Your Ref: OWQC23571
Our Ref: BR/125/19/PL
Please ask for:
Mr S Davis

Side & 2nd floor/roof extension to existing mixed use building to provide additional retail space at ground level, 1 No. new 1st floor studio flat in side extension & 2 No. studio flats in new 2nd floor.

1-2 The Parade Argyle Road Bognor Regis

project title	1-2 Argyle Road, Bognor Regis	
drawing title	Proposed Ground Floor Plan

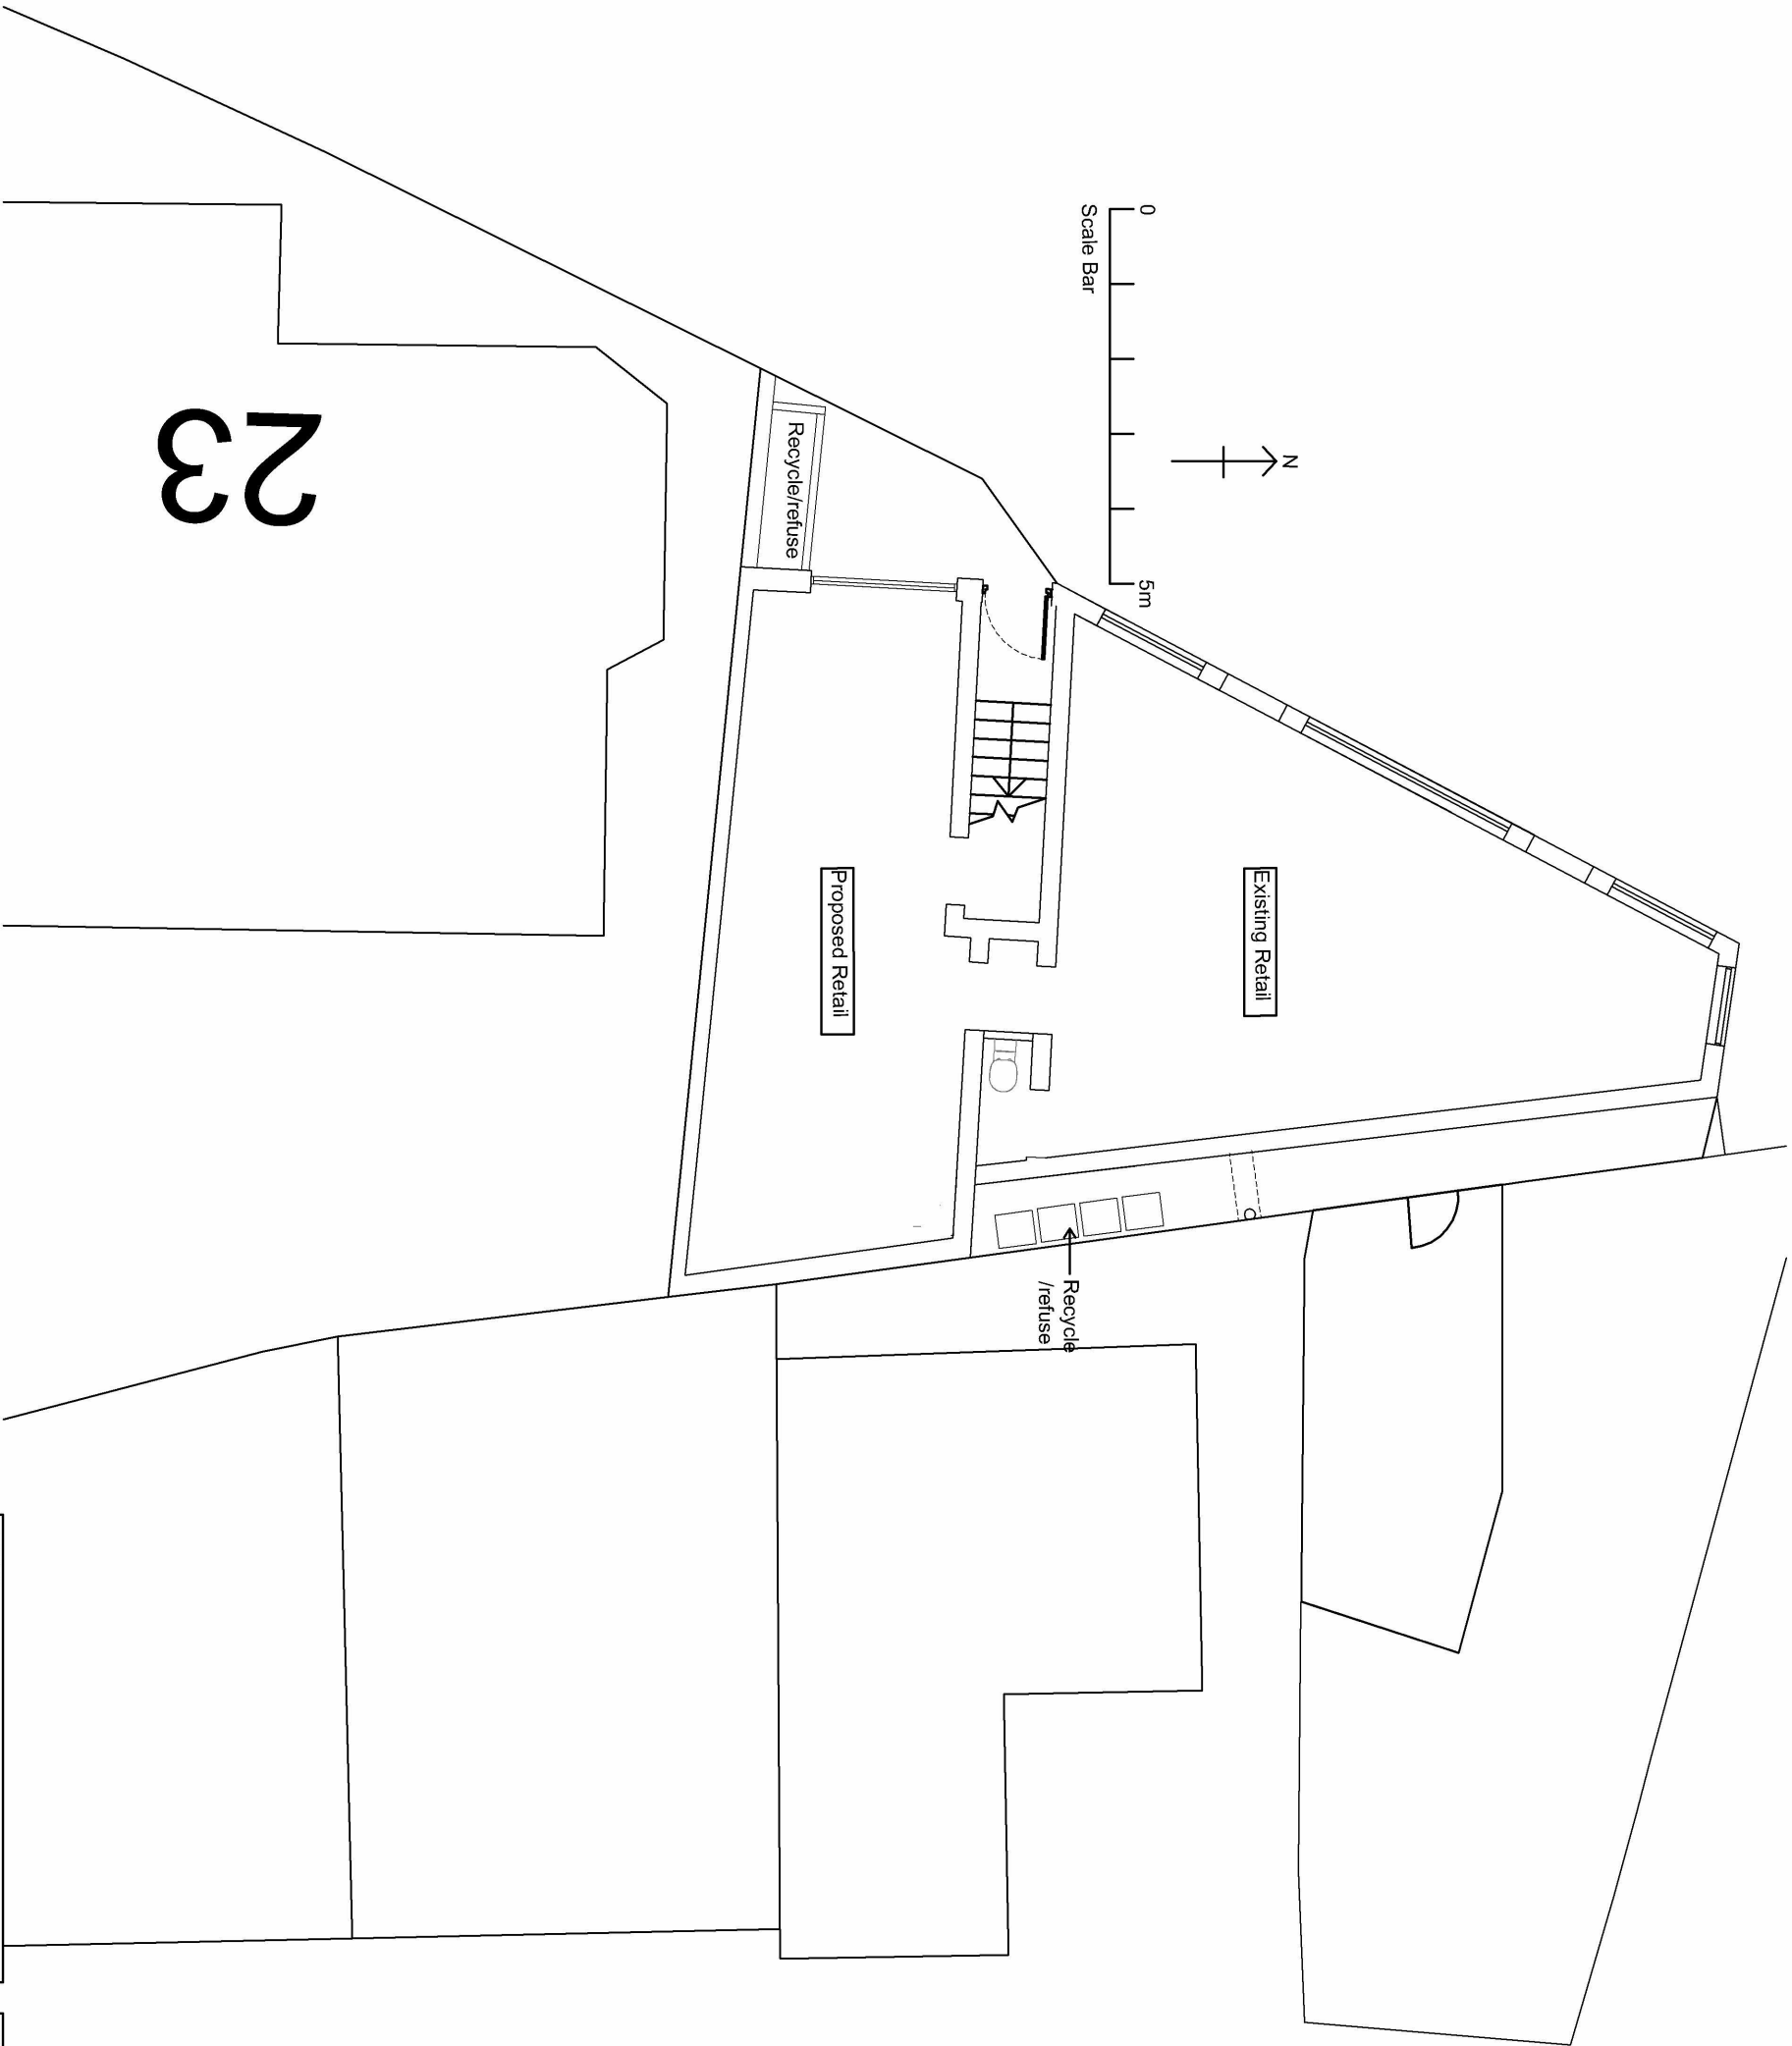
The side extension will also see the loss of two off-street parking spaces with the proposal unlikely to meet the needs of future occupiers of the proposed 3 No. studio flats. This will result in an increase in pressure for on-street parking spaces which will be harmful to the amenity of local residents by way of increased conflict/competition for existing spaces and the need for residents to park further away from their dwelling. It is therefore contrary to policies T SP1 and QE SP1 of the Arun Local Plan. It would appear that the plans do not include a proposal for cycle storage.

Proposed Street Scene

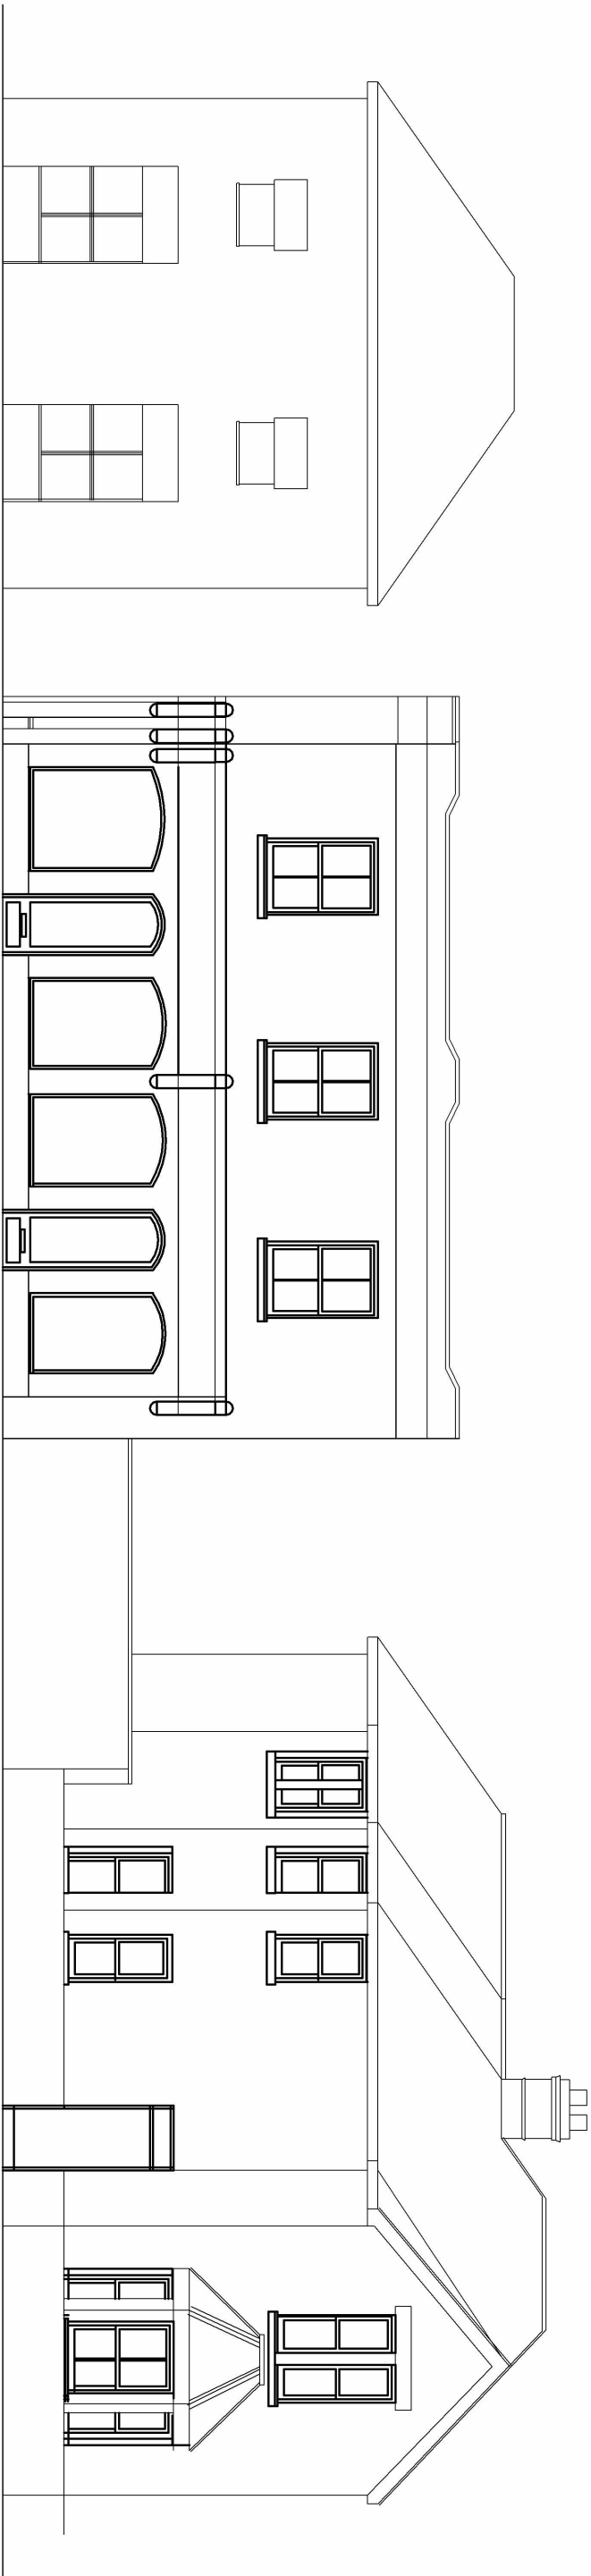
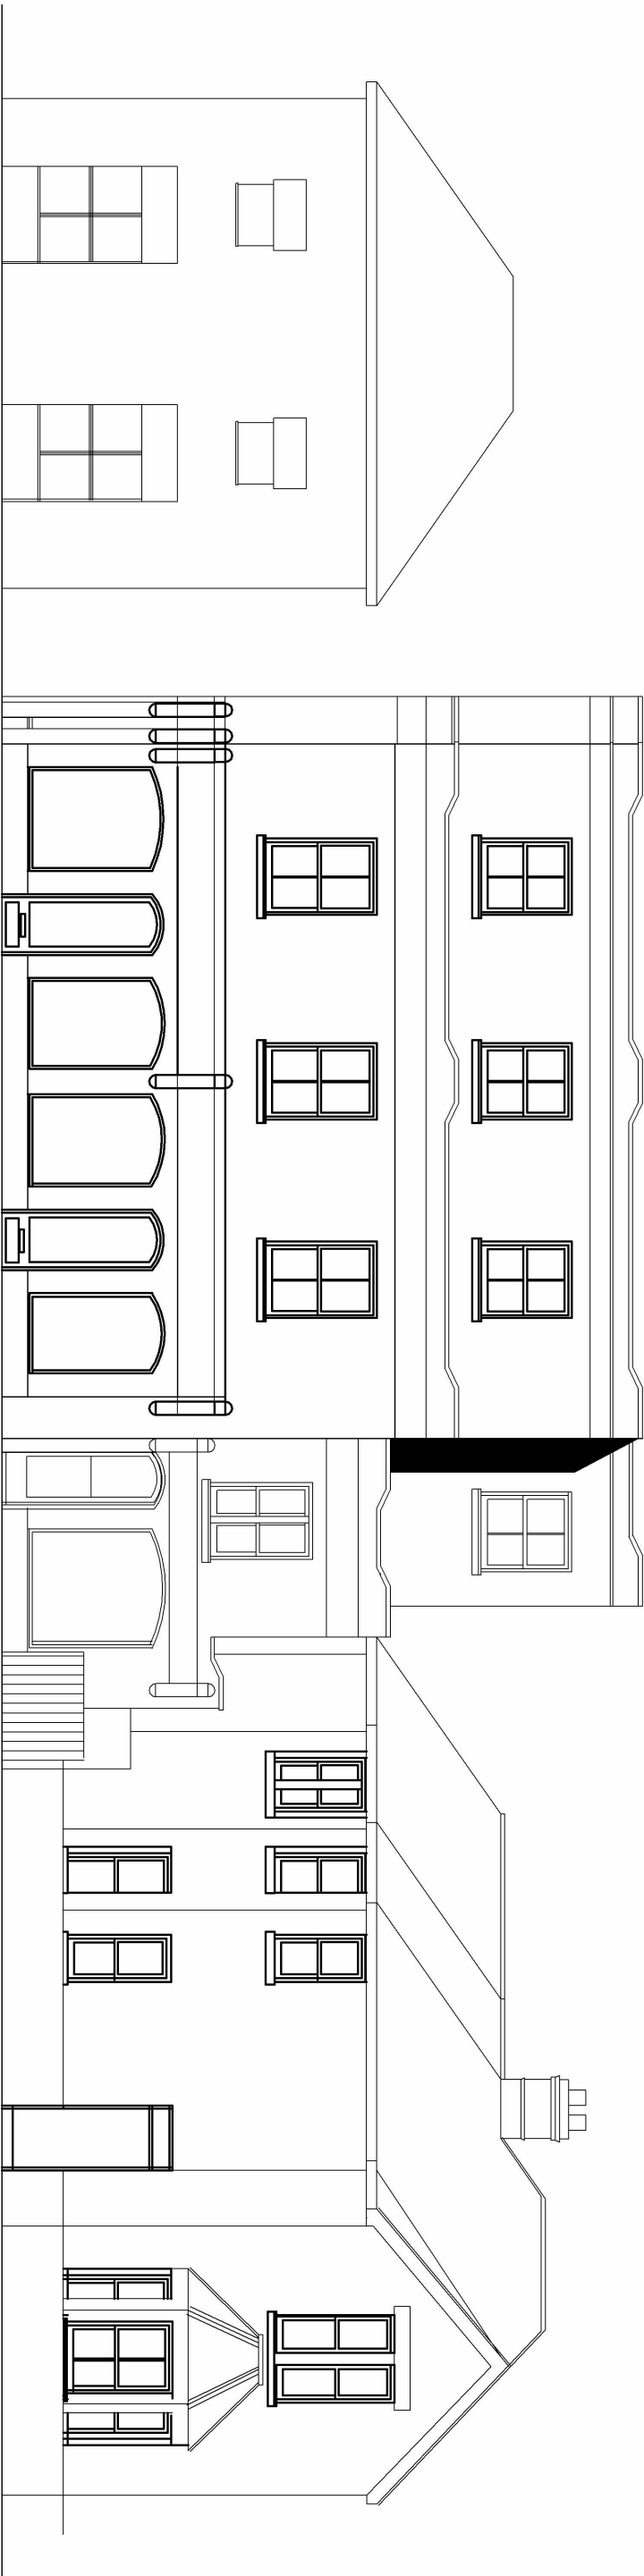
OBJECTION Members object to planning application BR/125/19/PL on the grounds that it is a departure from the Arun Local Plan Policy D DM4 whereby any extension or alteration does not have an adverse overshadowing, overlooking or overbearing effect on neighbouring properties. The proposal to increase the existing building by another storey, and to extend the footprint to the southern boundary wall, will adversely affect the neighbouring property and the gardens of those located at the rear.
